St Marys Resource Recovery Facility – Additional Information

This letter has been provided in response to request for additional information received on 20 August 2018 by the Bingo Recycling Pty Ltd (the Applicant) with regard to the St Marys Resource Recovery Facility Environmental Impact Statement (EIS) (SSD 17_8200). Please find below responses to each item raised.

Figure 6.2: Inbound Heavy Vehicle Haul Route

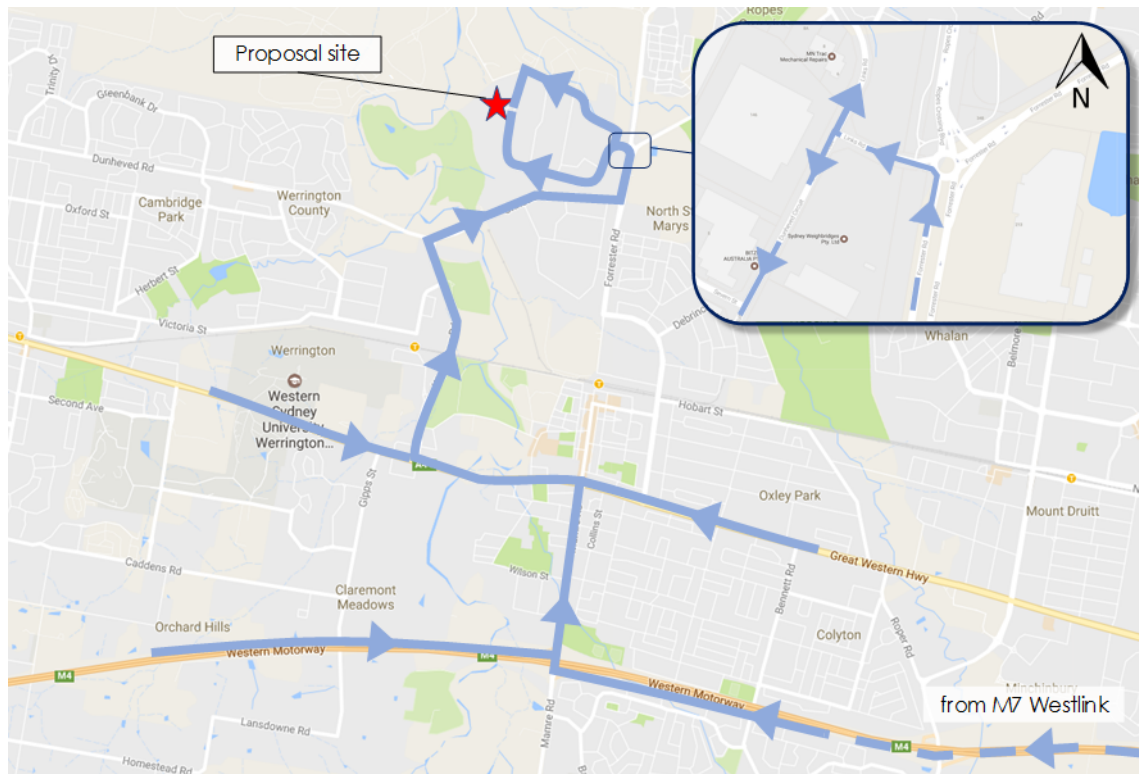
3. It is noted that Figures 4.7 and 7.1 of the EIS and Figures 6.2 and 6.3 of the Traffic Impact Assessment are not correct, and that Christie Street and Werrington Road would not be used by heavy vehicles approaching and leaving the site. Please provide an updated map showing the correct inbound and outbound heavy vehicle haul routes for the proposal, including the directions of travel.

It is acknowledged that the route shown in Figures 4.7 and 7.1 of the EIS and Figures 6.2 and 6.3 of the Traffic Impact Assessment is incorrect. An updated figure is provided in Attachment A.

As noted in Section 6.3 of Appendix of the EIS, the distribution of the site-generated traffic includes trucks travelling via the Great Western Highway, the M4 Western Motorway and the M7 Westlink Motorway. Within the vicinity of the site, heavy vehicles would travel to/from the site via Forrester Road, Links Road and Dunheved Circuit. Traffic associated with the Proposal site would travel to and from the site using the same haulage routes as current. It is noted that although Christie Street is an approved b-double route the primary route used to access the Proposal site would be via Forrester Road and Glossop Street. Further details regarding the proposed heavy vehicle routes will be provided in the Operational Traffic Management Plan for the Proposal.
